Greg Seese

APPROVED  
Limited building only review  
Project holder responsible for full compliance with the code

HARNETT COUNTY  
NORTH CAROLINA

2 OF 2

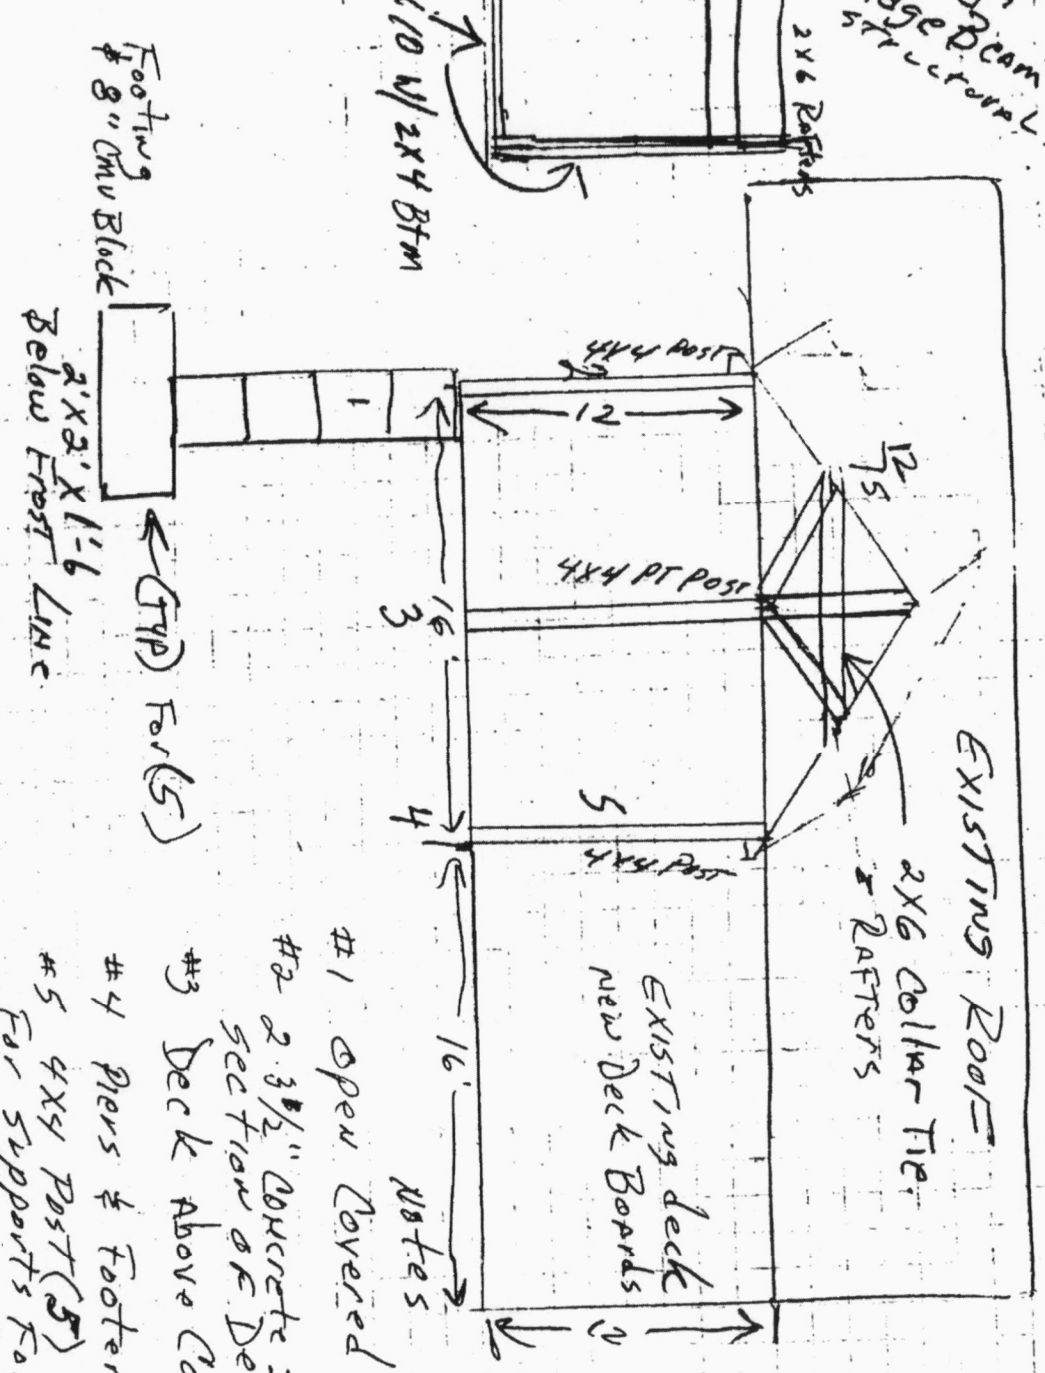
Must have ceiling joist in lower 1/3 of rafter span
